COMMENTS ON APPELLANT'S STATEMENT

Planning Inspectorate Reference:	APP/T2350/W/25/3367686
LPA Application Reference:	3/2024/1016

1 to 7 The Picture House George Street Whalley BB7 9TH

**WRITTEN REPRESENTATIONS SUBMITTED ON BEHALF OF
THE LOCAL PLANNING AUTHORITY**

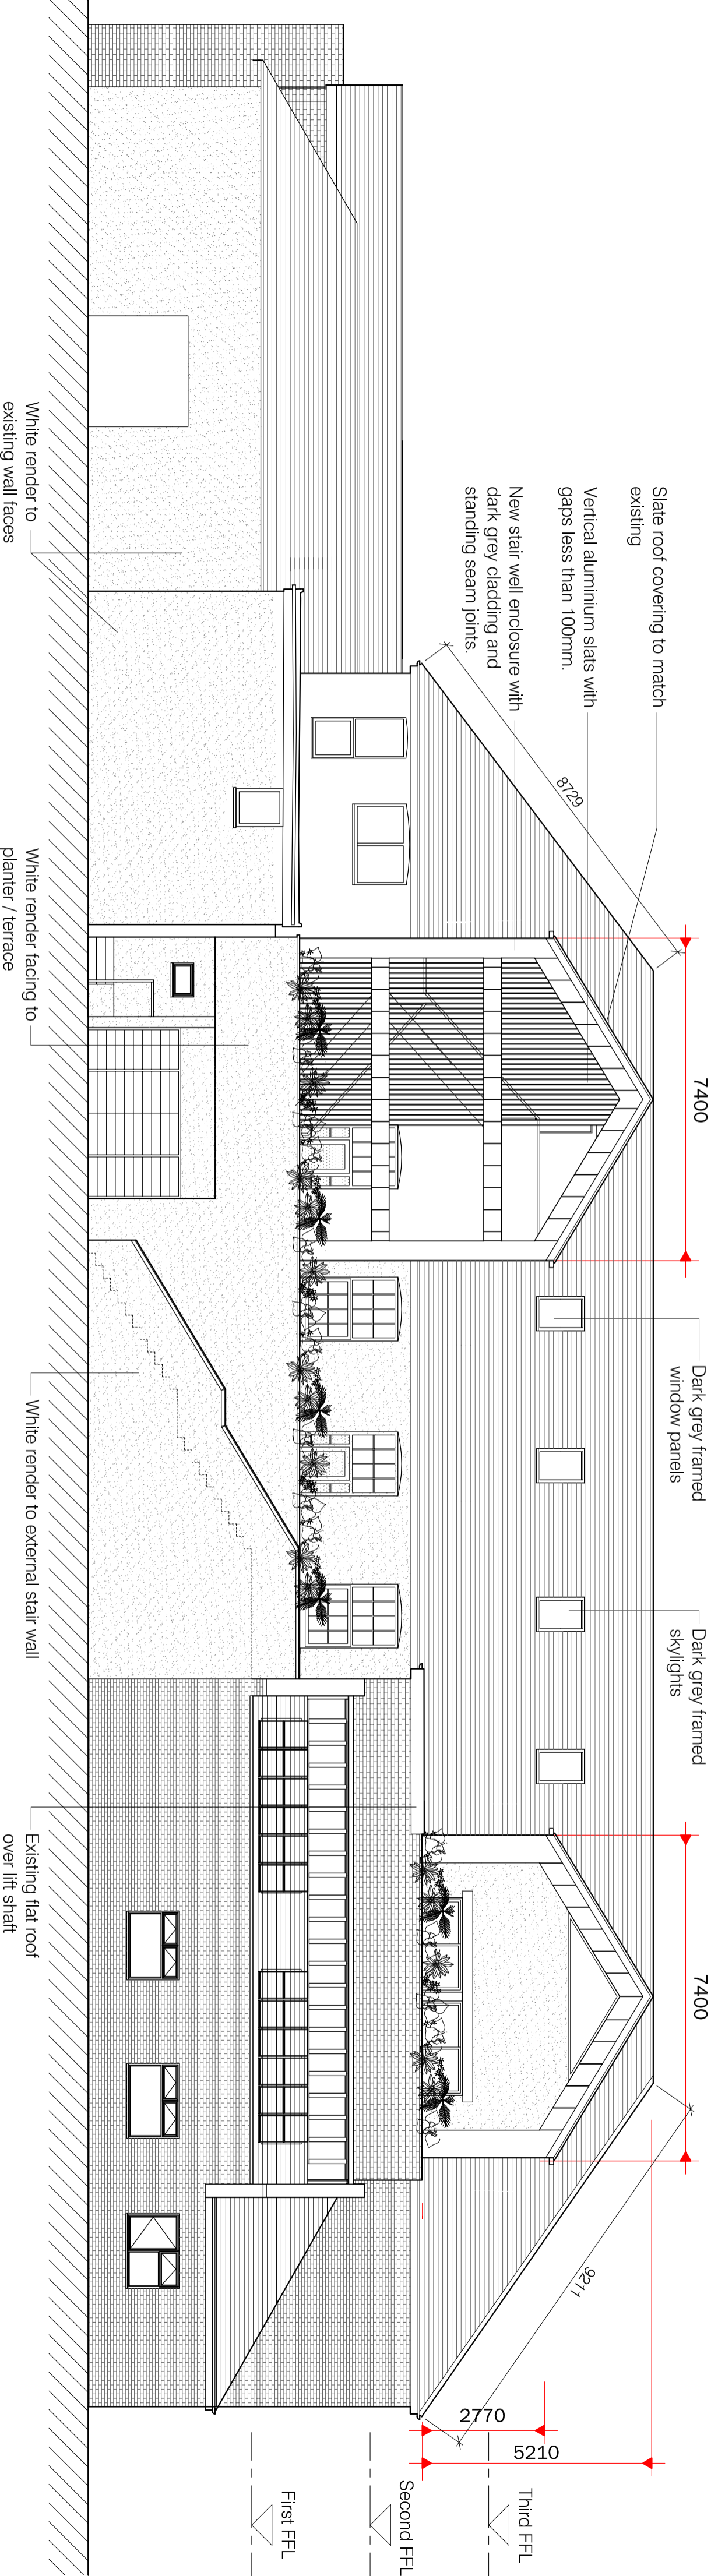
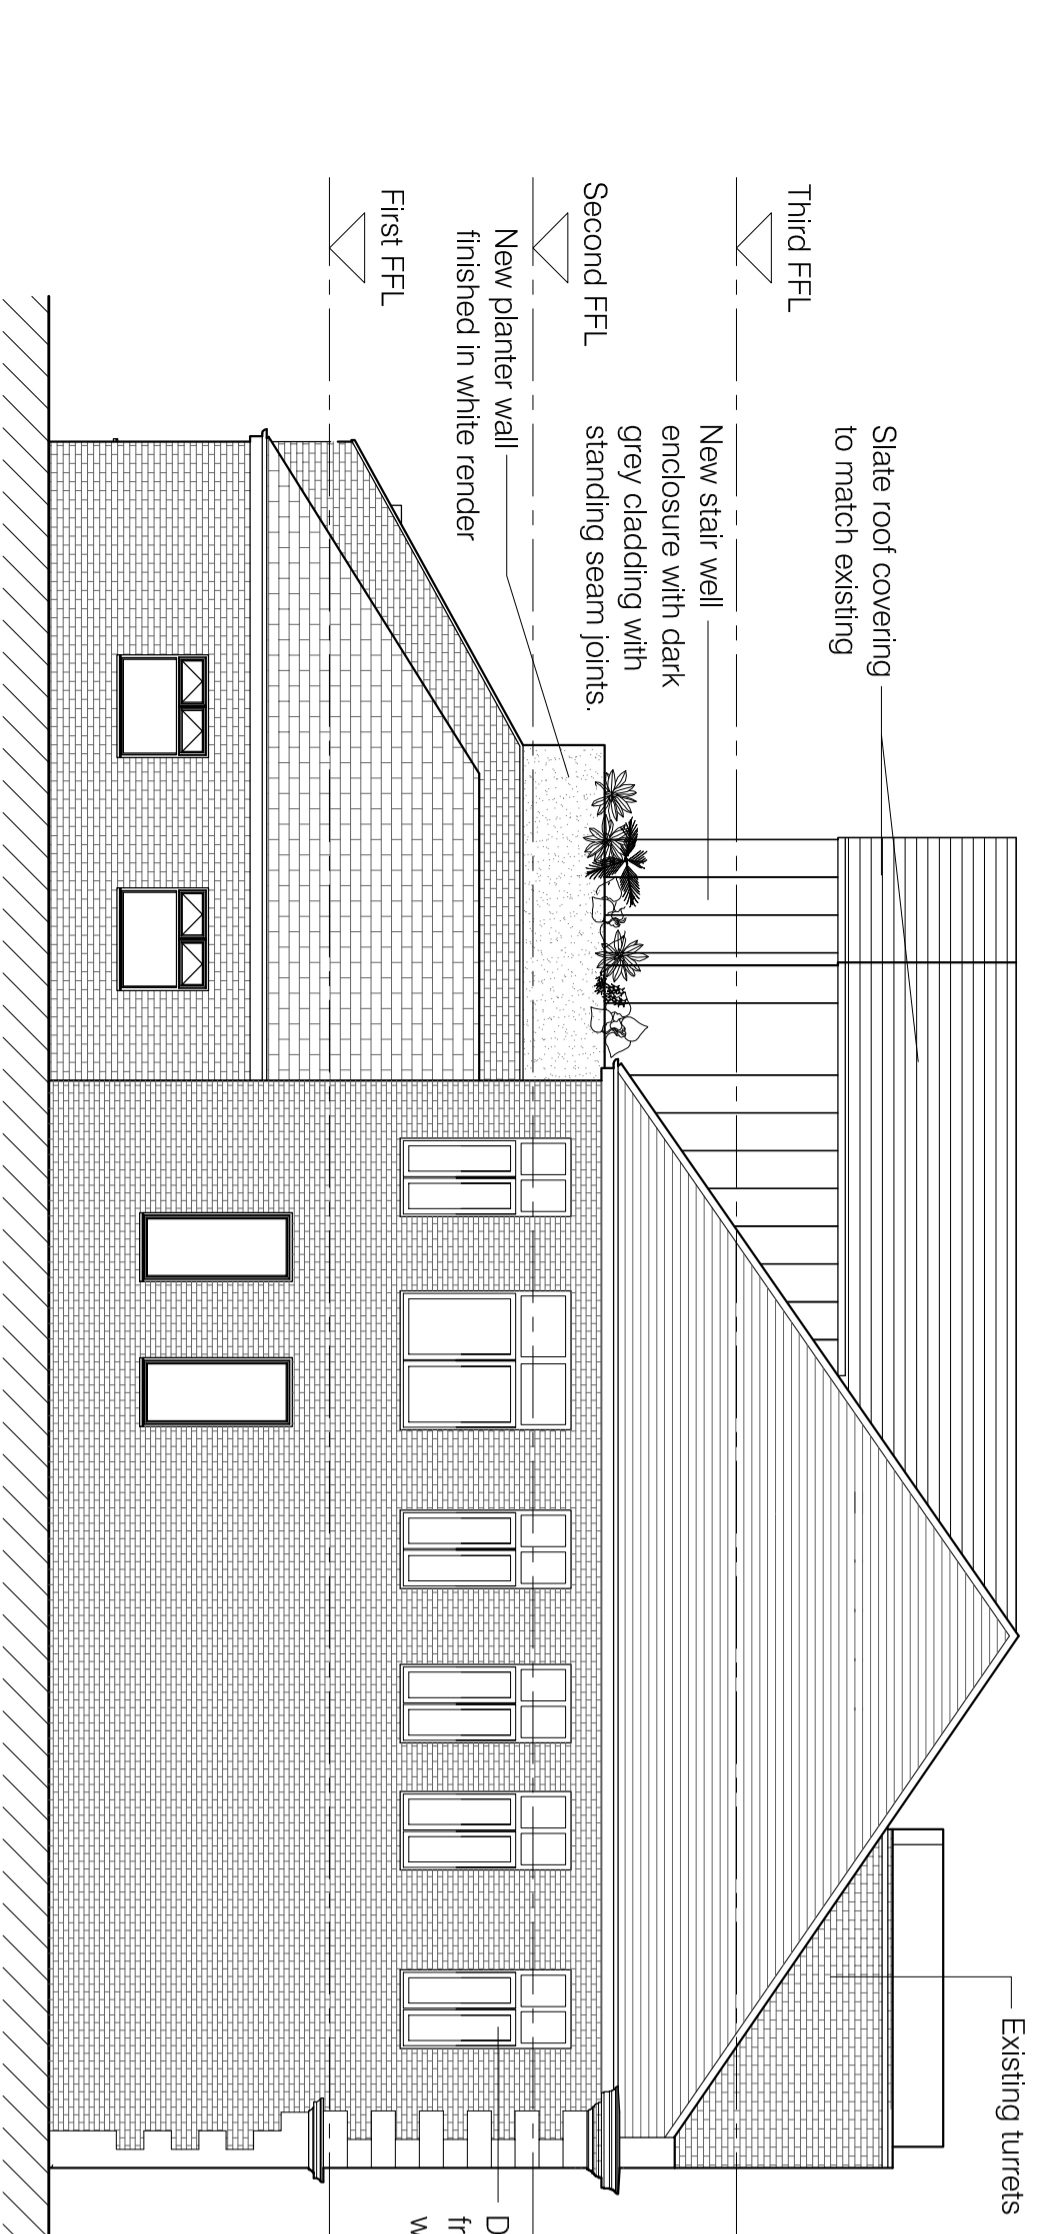
- 1.2 The appellant at 2.16 – 2.20 has suggested that the changes proposed to the original consent are not fundamental and do not diminish the quality of the development. The LPA disagrees with this view due to the reasons set out in the Committee Report and Decision Notice already forwarded for information. Moreover, it is clear that some of the proposed changes both individually and cumulatively result in harm to the adjacent Listed Buildings, the Whalley Conservation Area as well as the immediate residential properties and that this is evidenced within the report. This includes the complaints received by Ribble Valley Borough Council (RVBC) Environmental Health (Appendix One) regarding the on-going external lighting to the southern (rear) elevation of the building which is detrimental to residential amenity.

1.13 The appellant states at 4.40 – 4.46 their position on the Lighting Scheme which has been installed. These comments do not alter the Committee Report assessment which outlines why the scheme is not acceptable on this building in this location due to unacceptable lighting glare, visual appearance and harm to Whalley Conservation Area and the nearby Listed Buildings. The appellant has not presented any reasonable alternatives. The views of the RVBC Environmental Health on the submitted lighting assessment are made clear in the Committee Reports, Late Items Report and Decision Notice and therefore these are not reiterated here.

1.14 The appellant states at 4.47 – 4.51 their position on the Larch Cladding which has been installed. These comments do not alter the Committee Report assessment which outlines why this is not acceptable on this building in this location due to the design and visual appearance and harm to Whalley Conservation Area and the nearby Listed Buildings. The appellant has not presented any reasonable alternatives. The original staircase gable was to be fully enclosed in glazing, details of which were to be agreed. The open element of this gable has led to privacy concerns and complaints regarding the lighting scheme as installed for the nearby residents (as previously referred to in Appendix One).

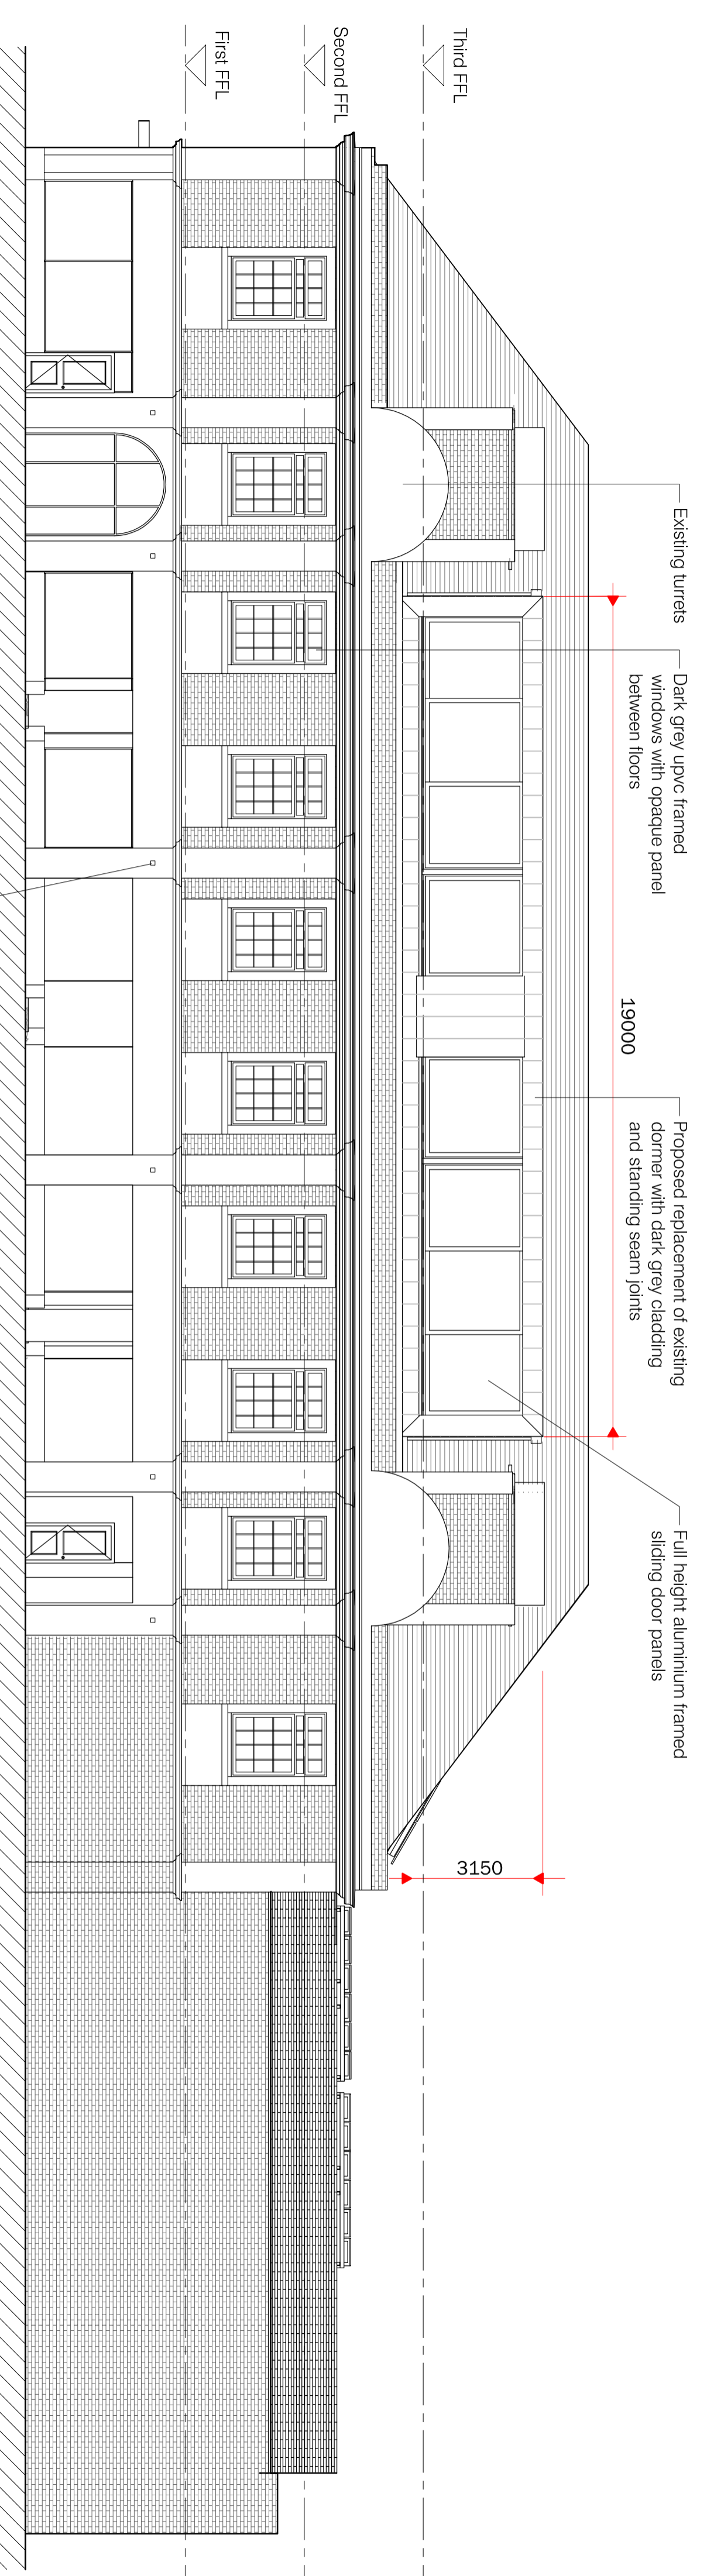
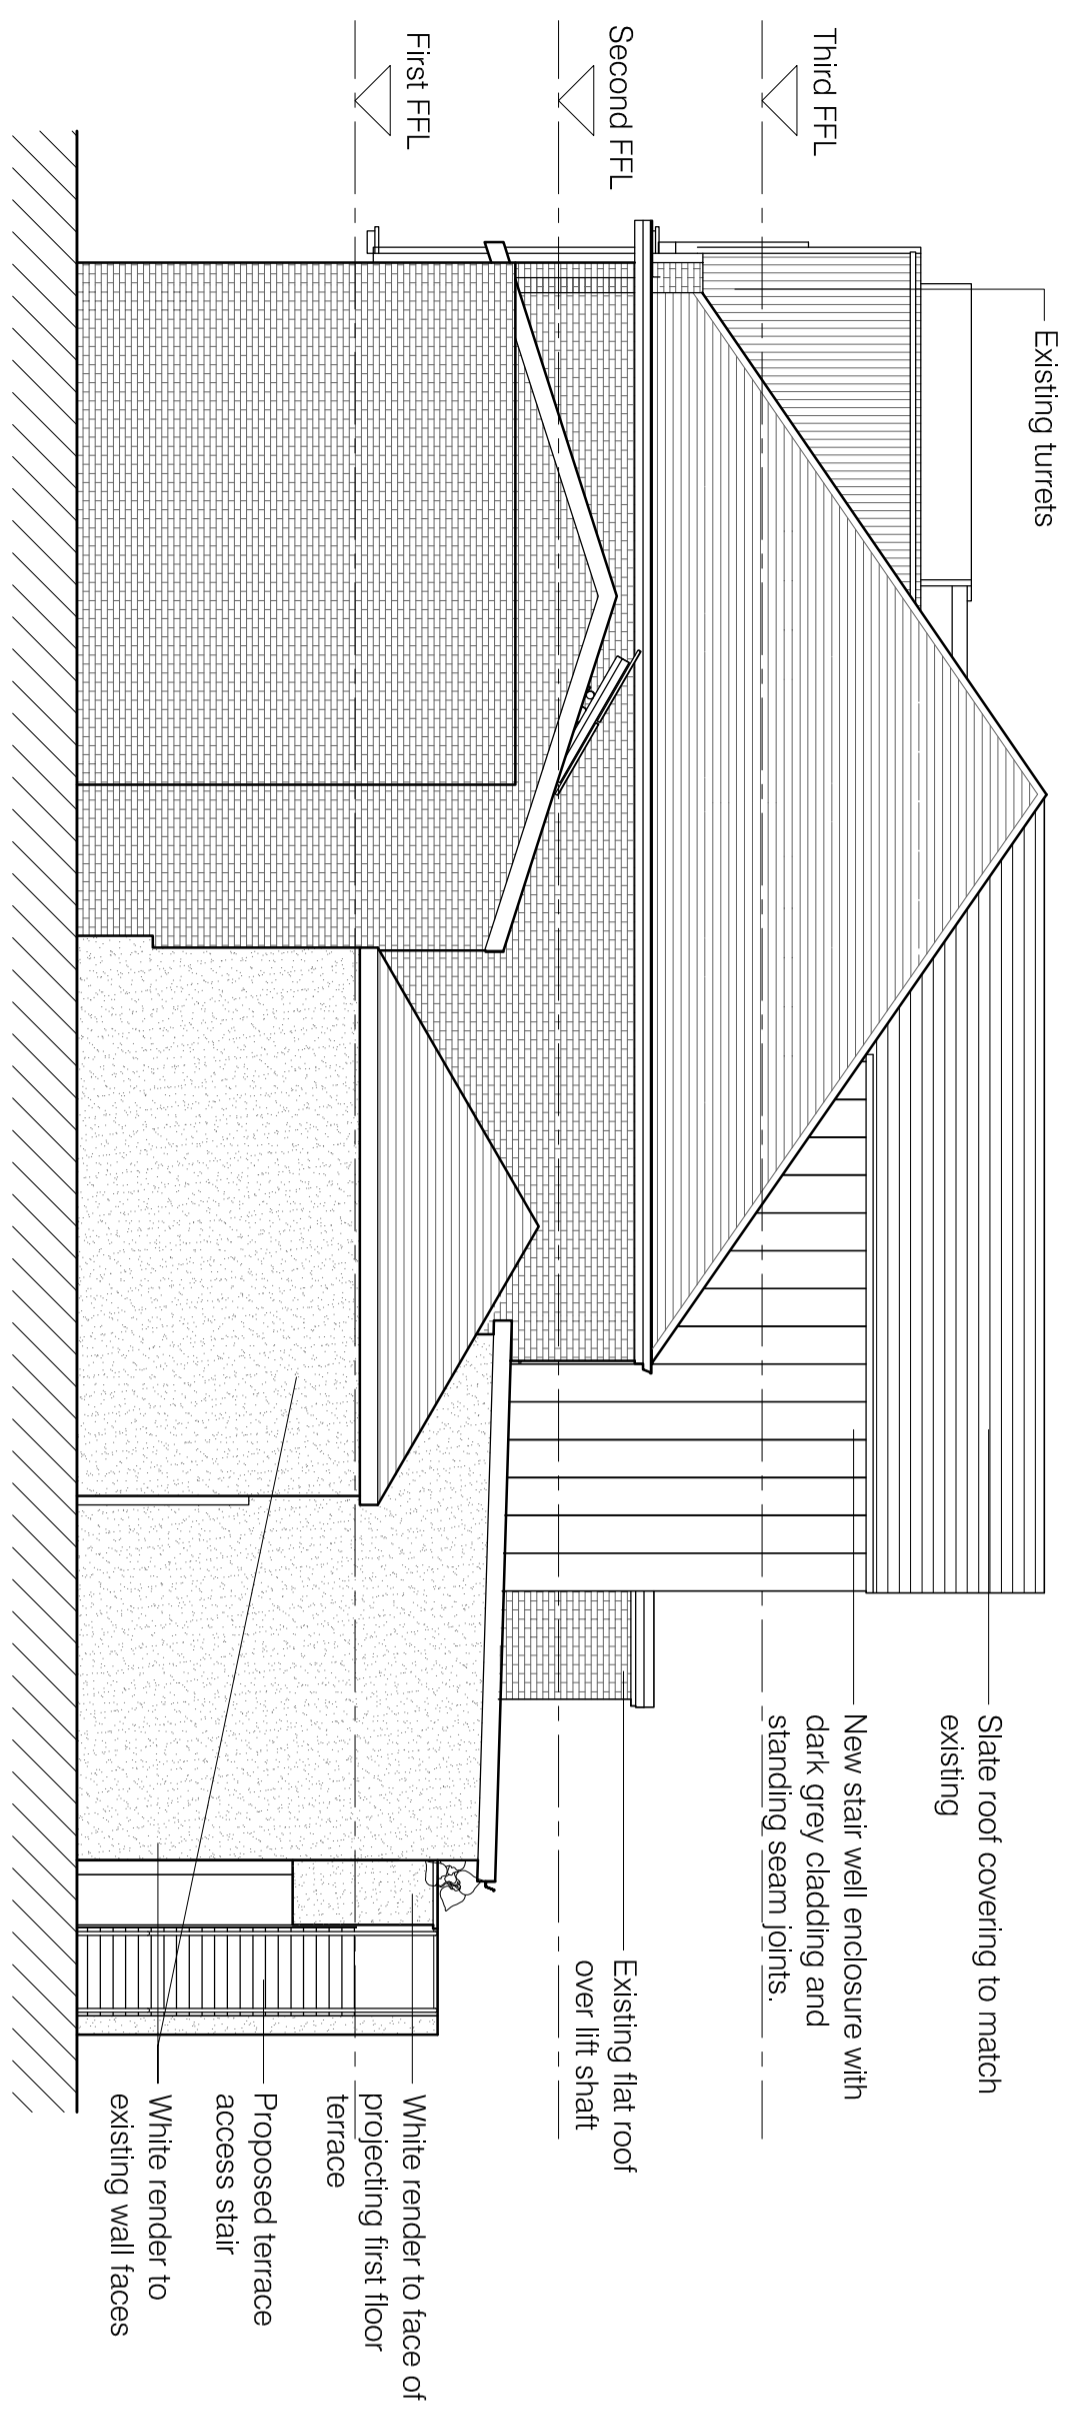
1.10 The appellant states at 4.6 – 4.27 their position on the UPVC windows which have been installed. These comments do not alter the Committee Report assessment which outlines why the installed UPVC windows are not acceptable on this building in this location due to their design and visual appearance and resultant harm to Whalley Conservation Area and the nearby Listed Buildings. The appellant has not presented any alternatives. The appellant submitted a survey of other properties within Whalley Conservation area which have UPVC; however no specific details have been provided except for a map-based project. Whilst there may be UPVC windows evident elsewhere in the conservation area, they differ in design and impact. Not all of them have the benefit of planning permission. Photographs of the building prior to any work being undertaken (Appendix Four) clearly shows that there was timber windows installed at first floor including sash windows on the gable which have since been removed and replaced with bulky Grey upvc windows.

1.11 The appellant states at 4.28 – 4.32 their position on the Grey Aluminium Cladding which has been installed. These comments do not alter the Committee Report assessment which outlines why they are not acceptable on this building in this location due to the design and visual appearance and resultant harm to Whalley Conservation Area and the nearby Listed Buildings. The appellant has not presented any alternatives but states that aluminium has better fire resistance in terms of the central panel as well as thermal performance. However, there are other alternatives which would have less visual impact within the conservation area which have not been considered. The Committee Report also outlines the views of the Council's Building Control Team in terms of alternatives which achieve the same desired fire safety outcomes.
